Applicant: Heyford Park Developments Ltd

Proposal: Partial discharge of condition 9 (tree protection) (Relates to Phase 10 only) of 18/00825/HYBRID

DRAWING NO. HEYF-5-1300 REV F

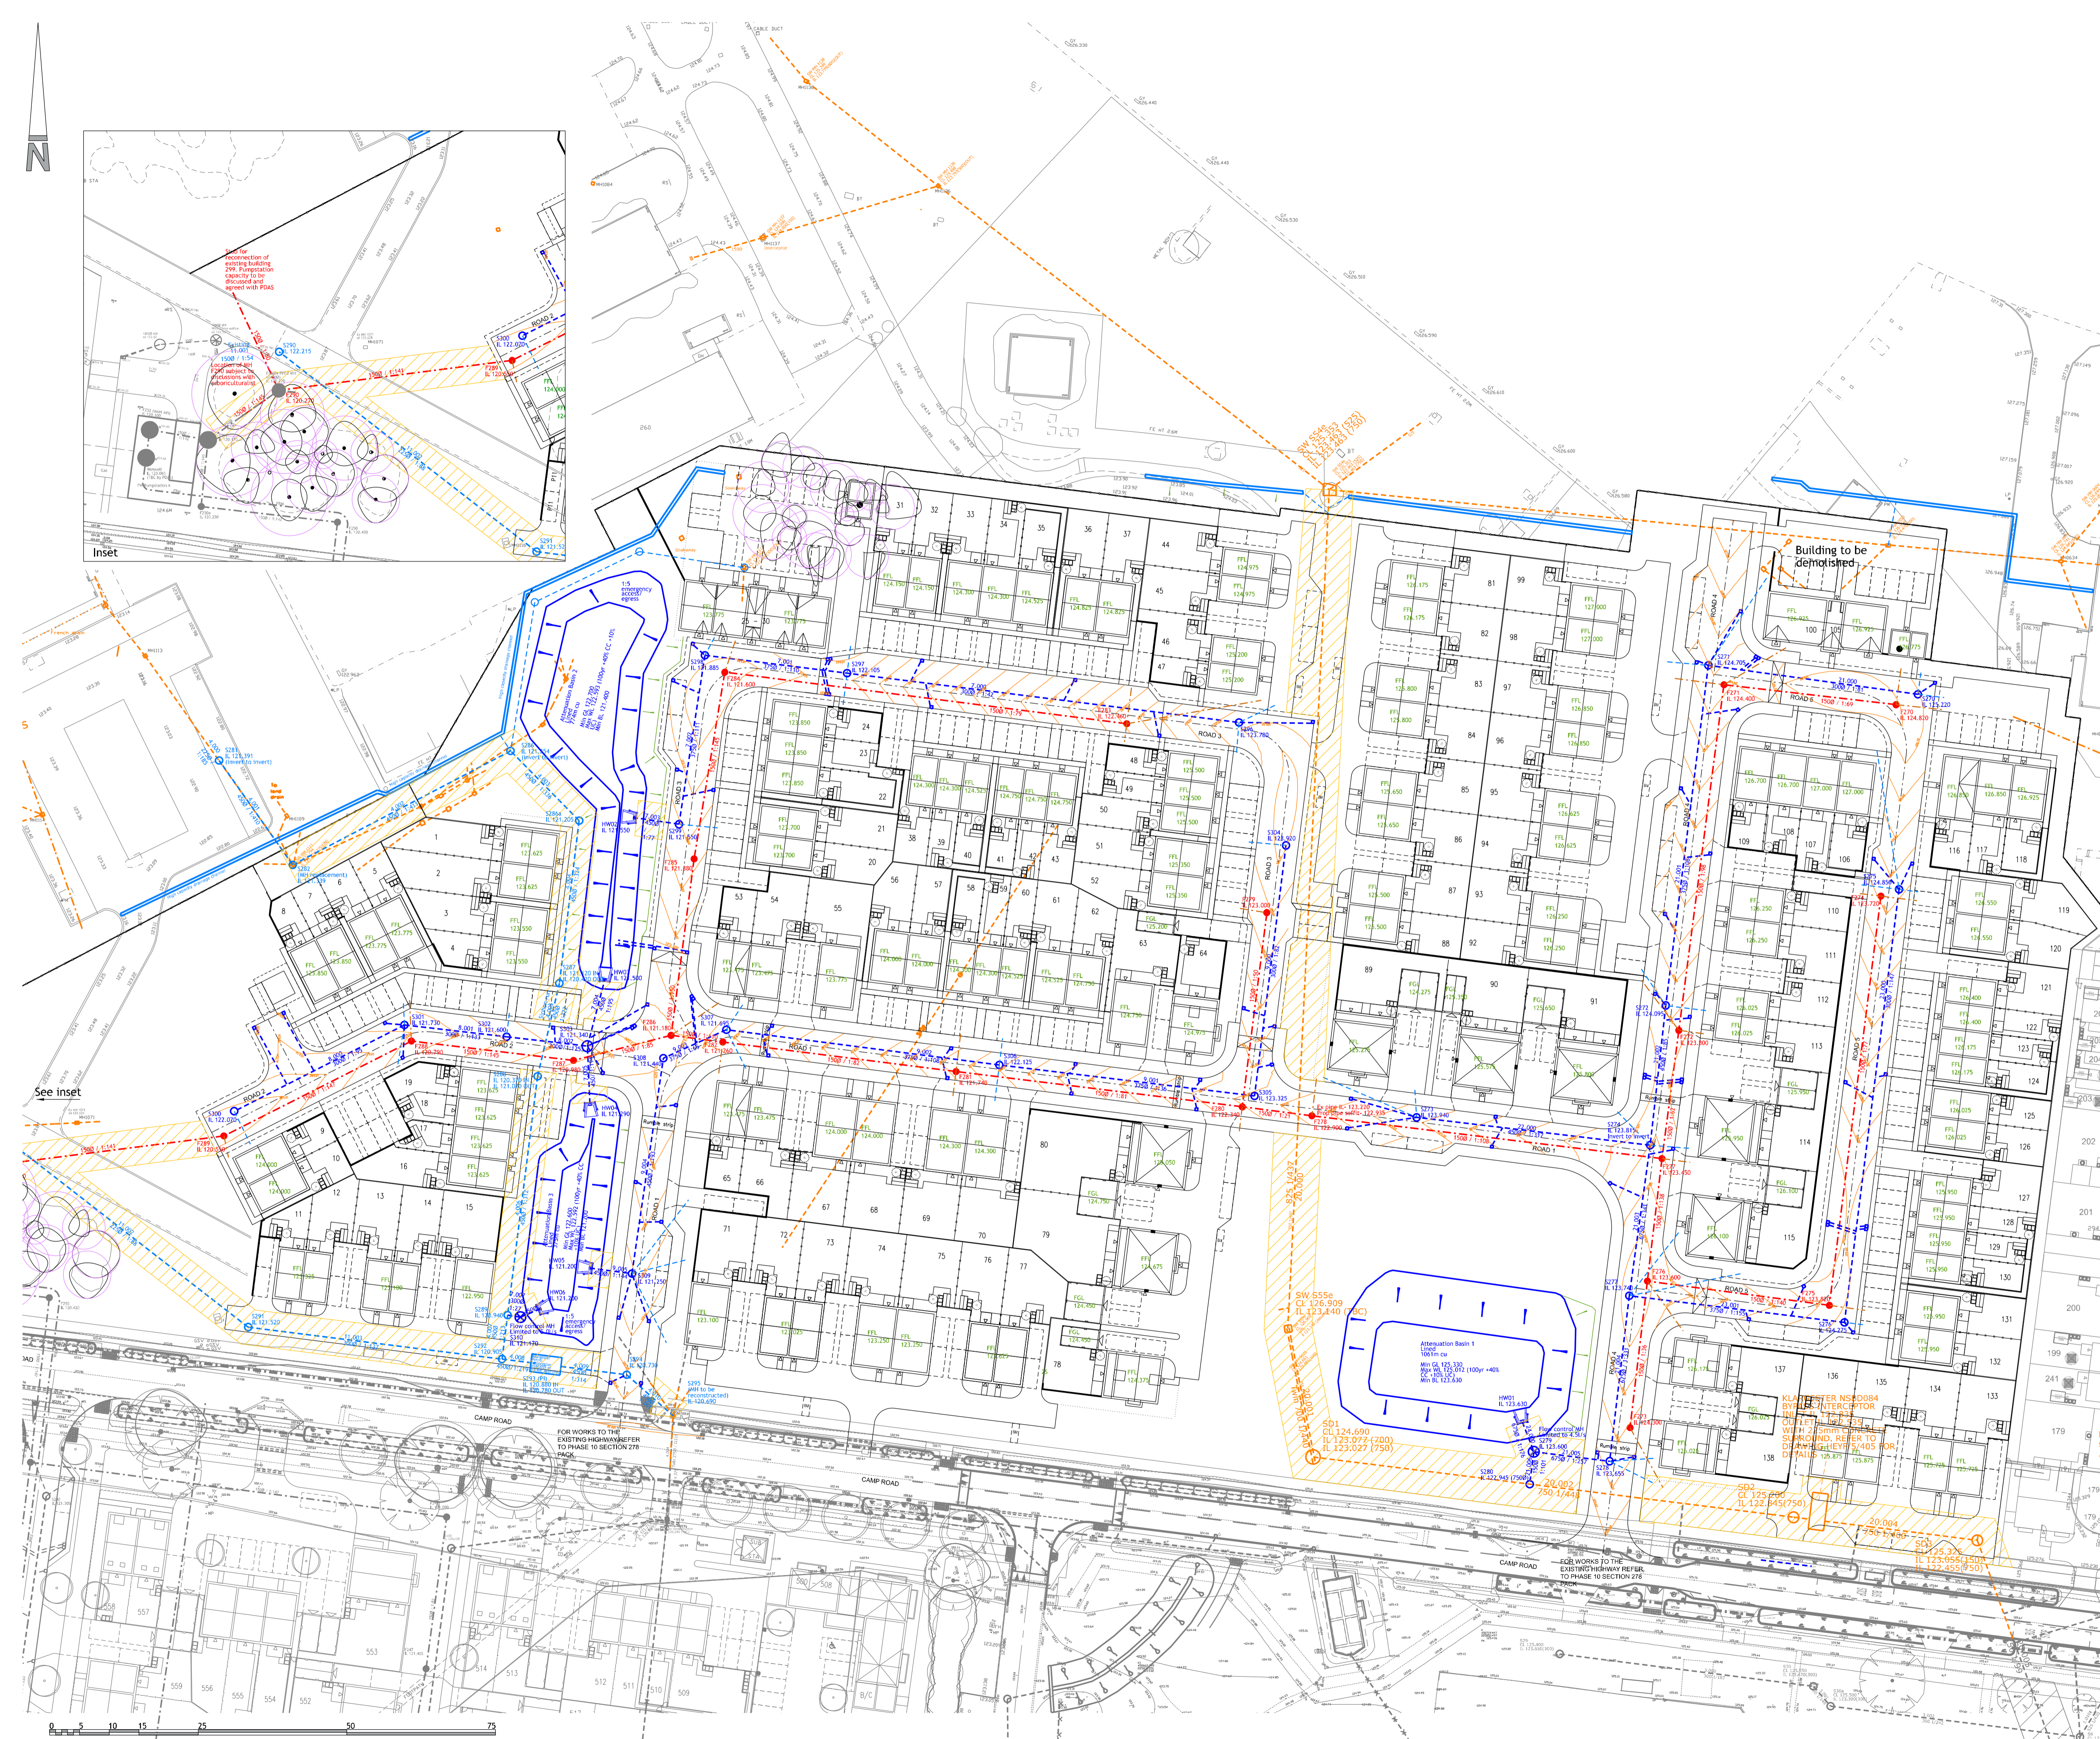
'Overall the AMS covers items required to discharge the condition. The report highlights a requirement for arboricultural supervision during the installation of inspection chamber F290. I'd like to add an advisory onto this DISC that the project Arboriculturalist is to report to CDC when they are consulted on this, in order to agree with CDC the proposed impact of installation before proceeding.'

4.2 In response to the consultation comments of CDC Arboriculture an updated Arboricultural Impact Statement was submitted to include the recommended advisory note in respect of inspection chamber F290.
